CITY OF ALBUQUERQUE

September 13, 2024

RE: Event Center
1611 Airtech Ct. SE
Grading and Drainage Plans
Engineer's Stamp Date: 06/20/2024
Hydrology File: N15D017

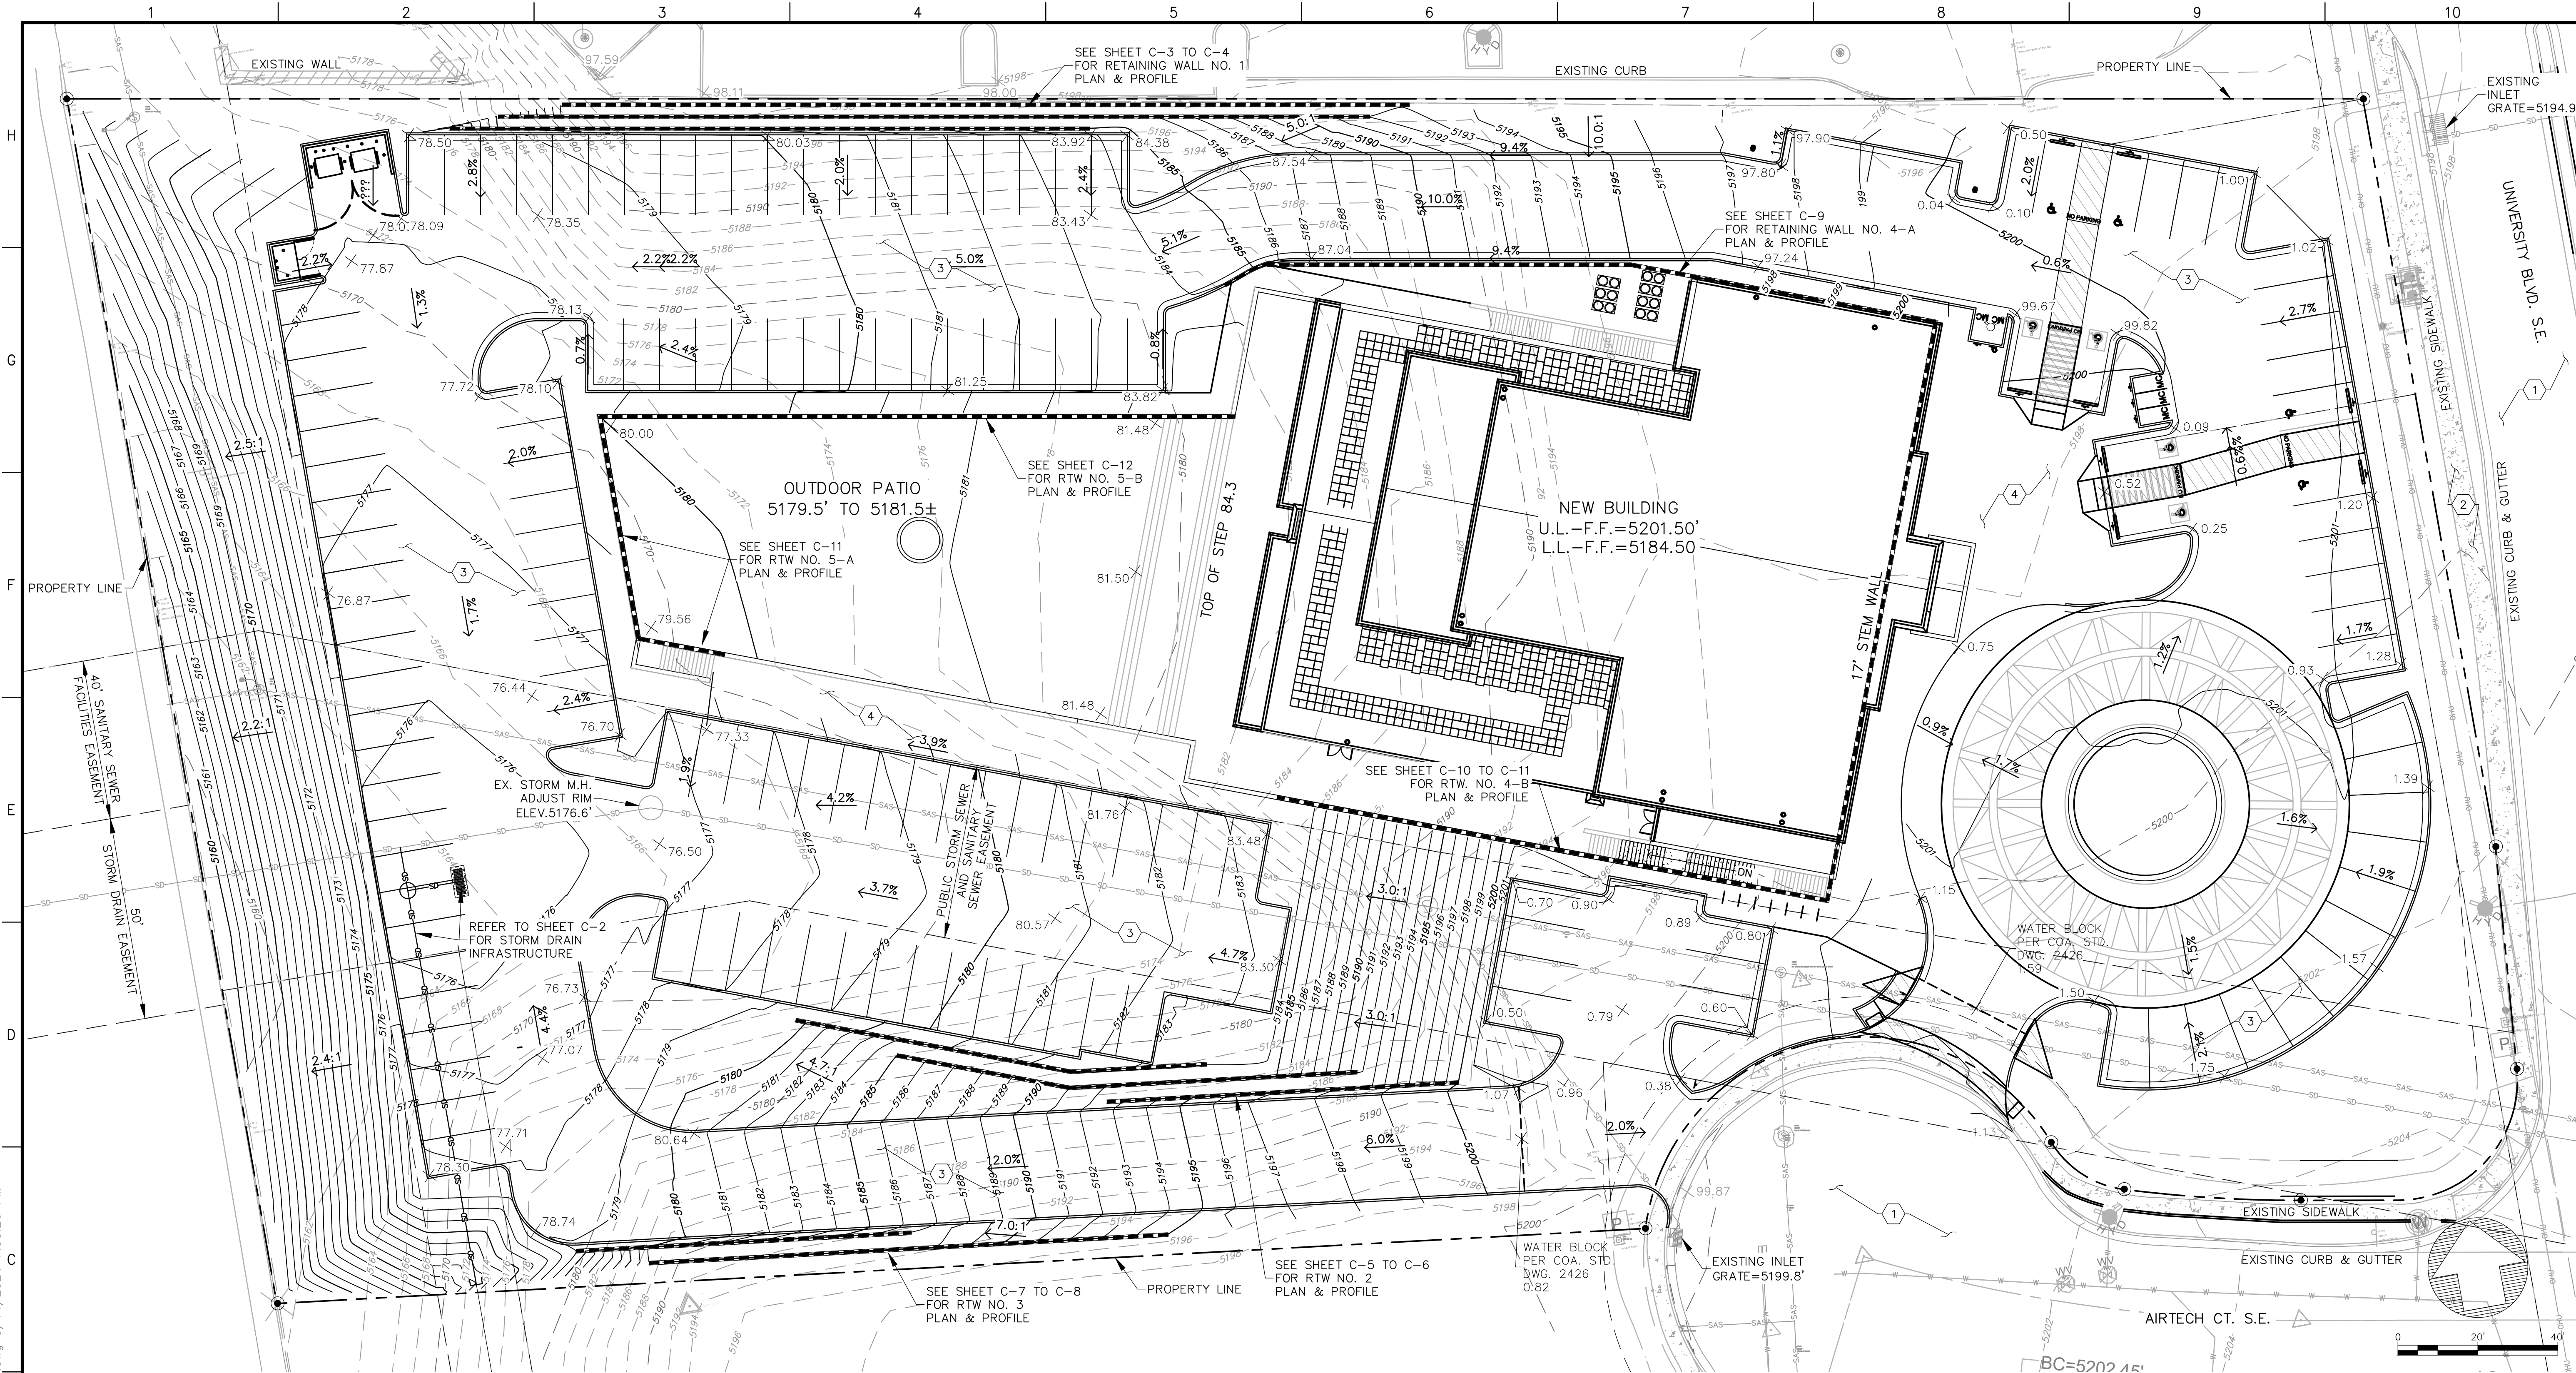
1. Rough grading must stay away 30 ft from the property lines until a firm design and assurance from a structural engineer stating that the retaining walls as designed will be buildable and will not create safety issues with the adjacent property.
2. Please provide garden wall design details. Total wall height (garden wall on top of the retaining wall) must be reviewed and approved by the Code Enforcement division.
3. Install a manhole at the location that the Type D inlet with the 18-in storm drain connecting to the existing 60-in pipe.
